AA7403C Clitheroe Road, Whalley

RE: Non-Material Amendment Application Land off Clitheroe Road Whalley (Lawsonsteads phase 2) BB7 9RG.

Planning Reference: 3/2026/0585

AA7403C Clitheroe Road
Whalley
PROPOSED SURFACE
TREATMENT LAYOUTS

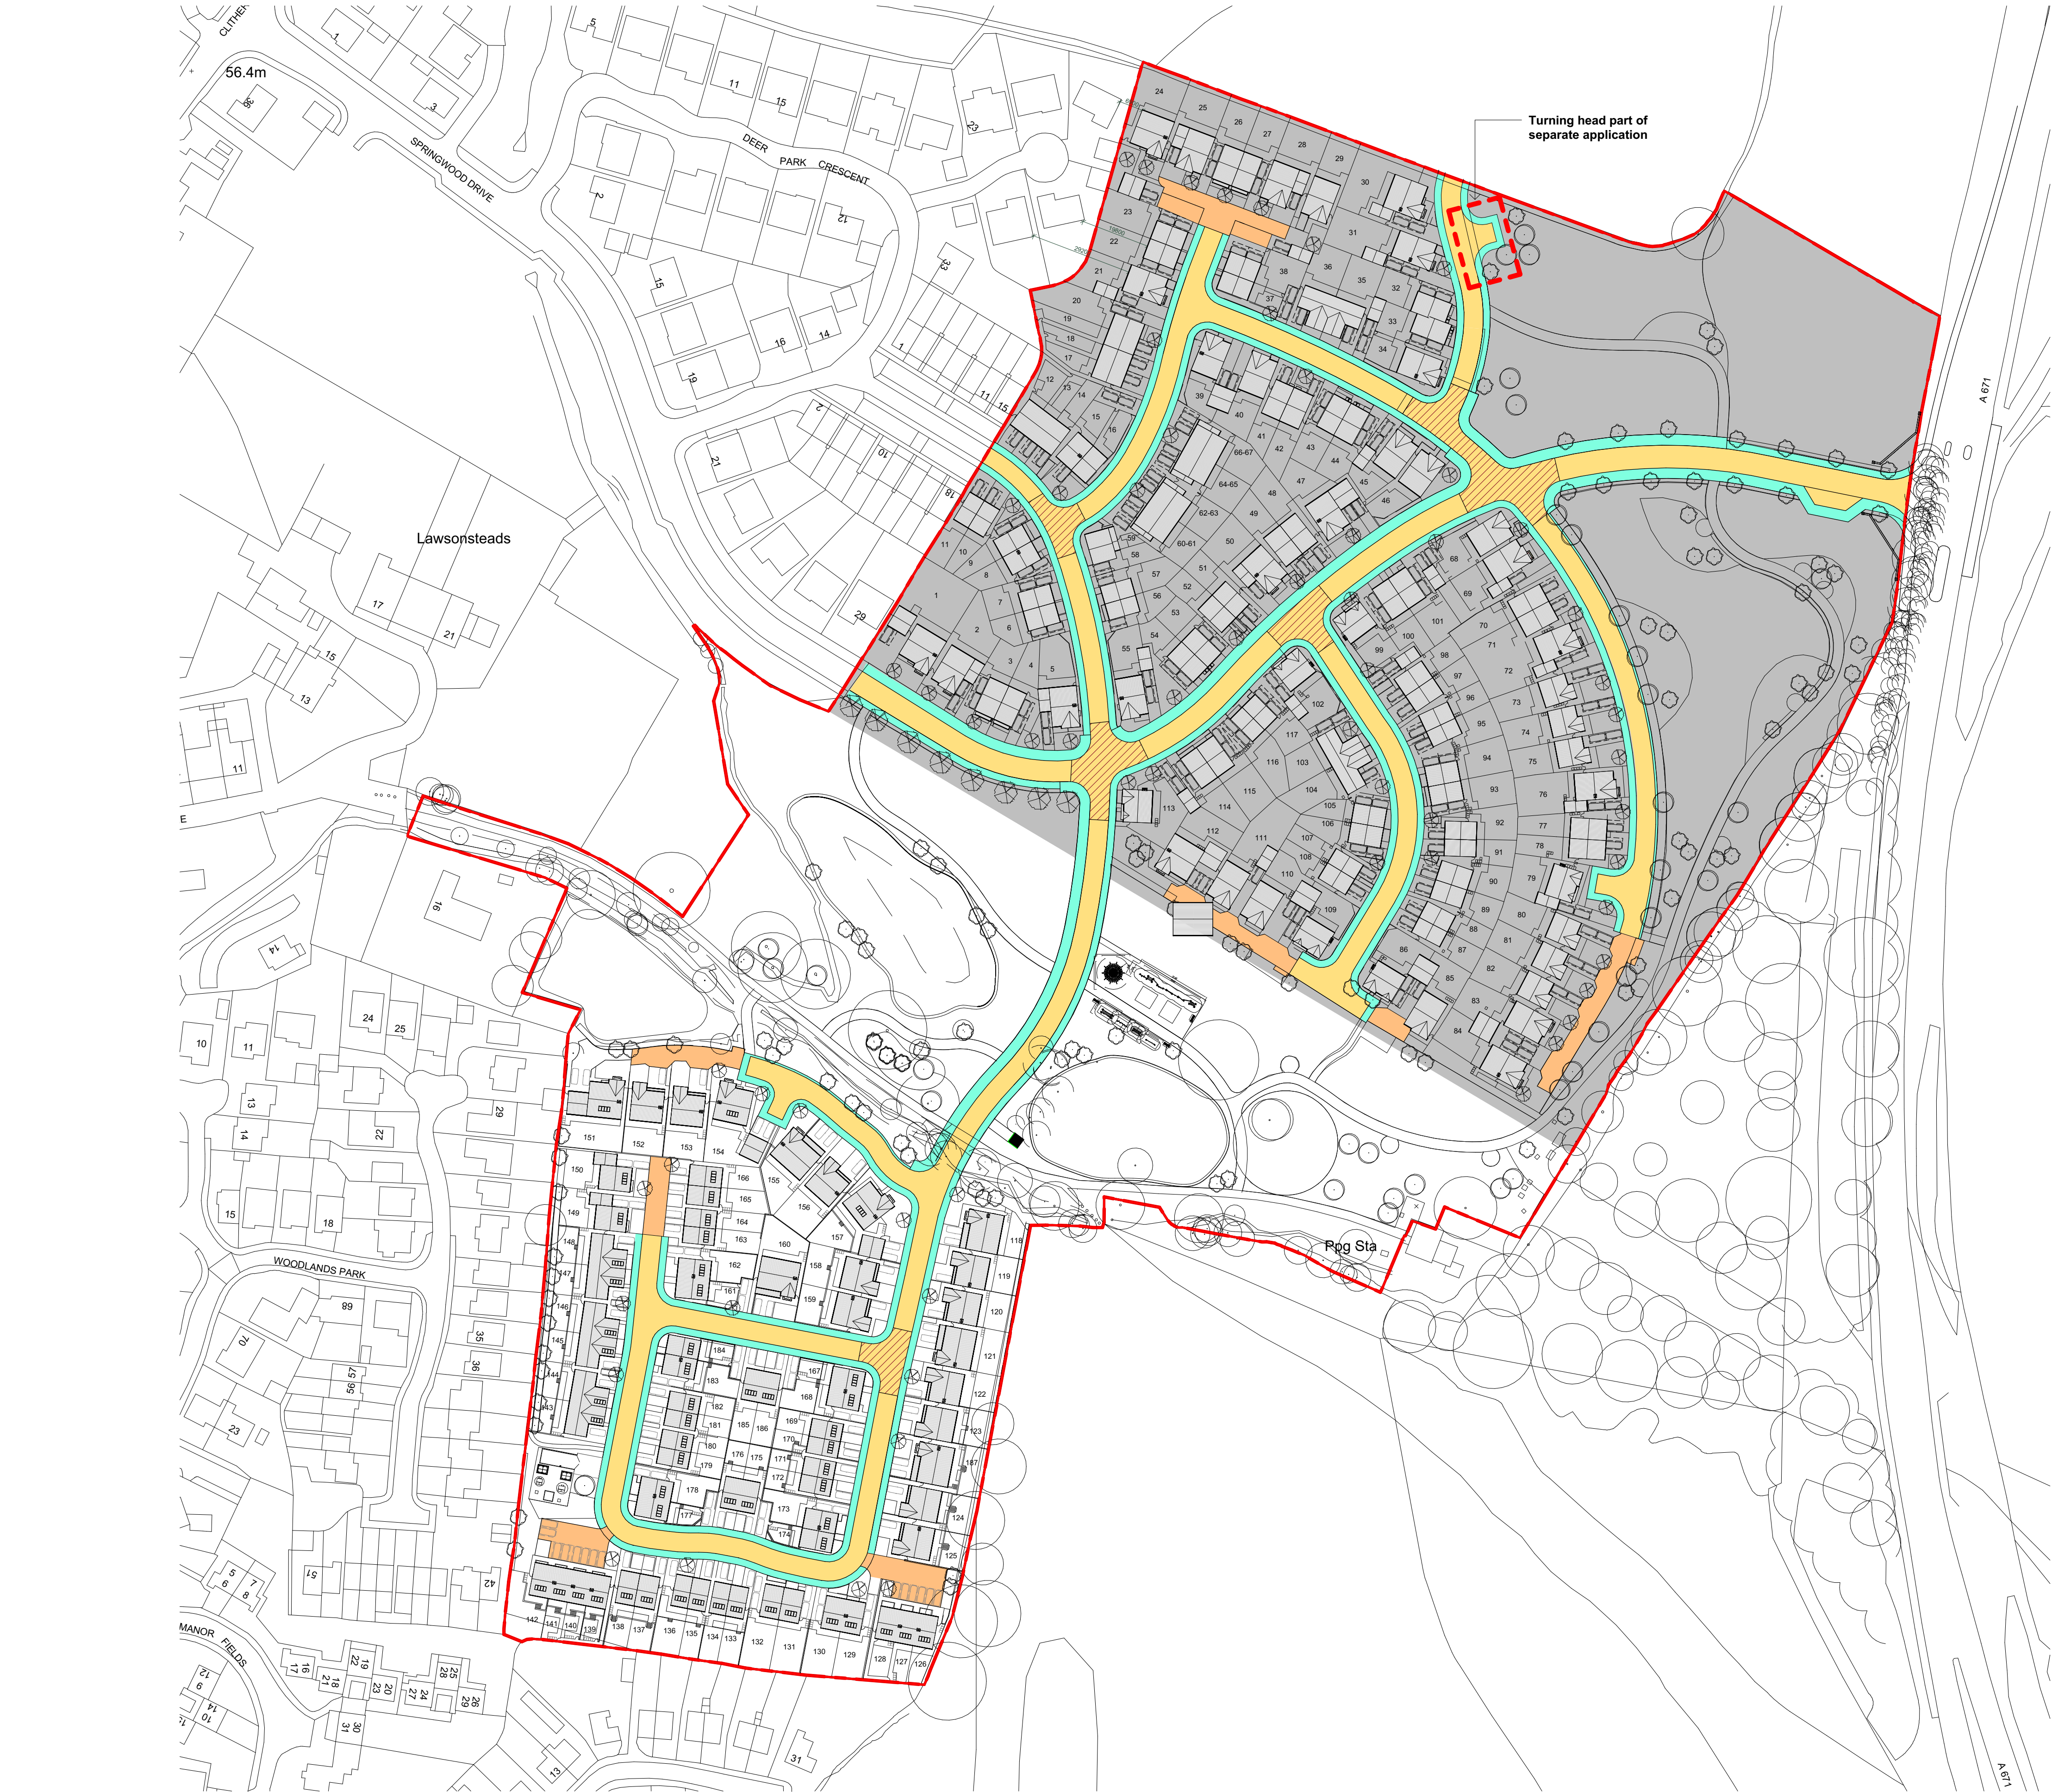
1. **Driveway Width Amendments:** Minor adjustments to the driveway widths to improve vehicle manoeuvrability and parking accessibility while maintaining adequate soft landscaping, responding practically to site layout constraints.

3. **Boundary Amendments:** Minor refinements to plot boundaries to improve site layout efficiency and reflect practical on-site alignment dictated by existing site conditions.

AA7403C Clitheroe Road
Whalley
PROPOSED UNIT MIX PLAN
(ROOF PLAN)

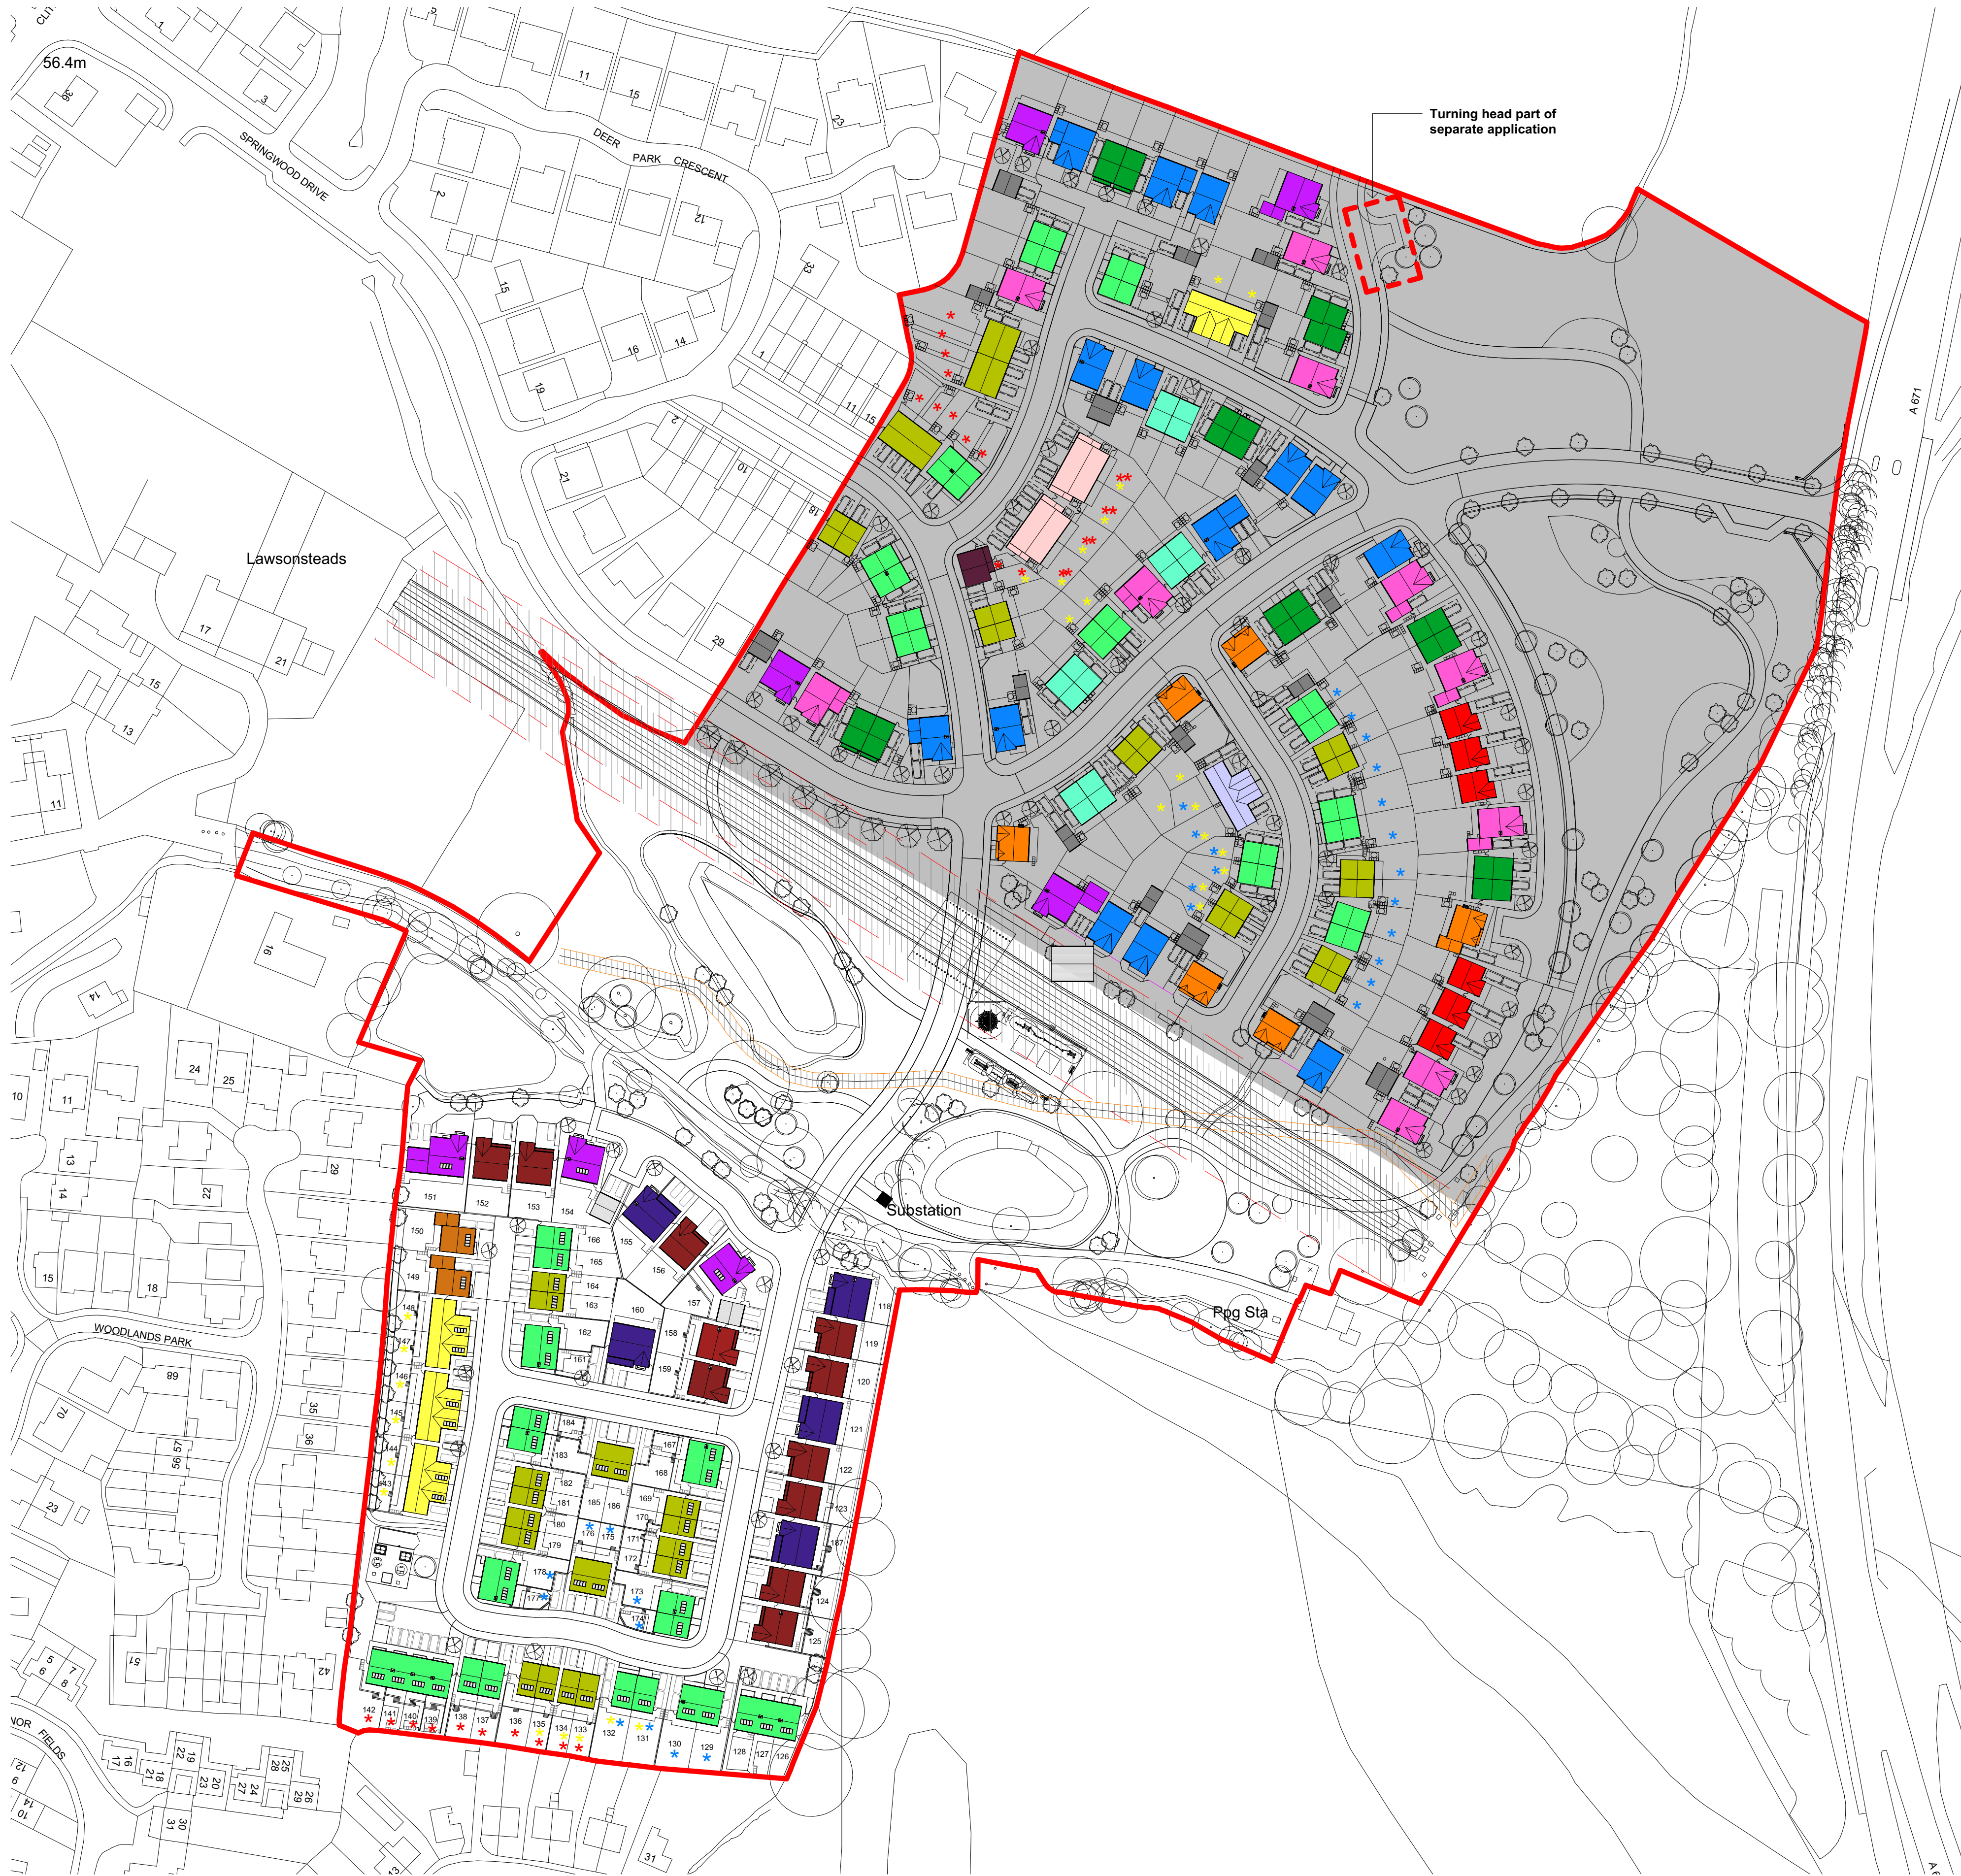
2. **Handing of Plot 124:** The architectural layout of Plot 124 has been "handed" (mirrored) to better align with the site topography and orientation, overcoming specific site constraints around accesses and conveyancing boundaries.

5. **Amendment to Chimney Locations:** Minor repositioning of the chimneys on specific plots to deal with the practicalities of construction access and fire safety along party wall lines.
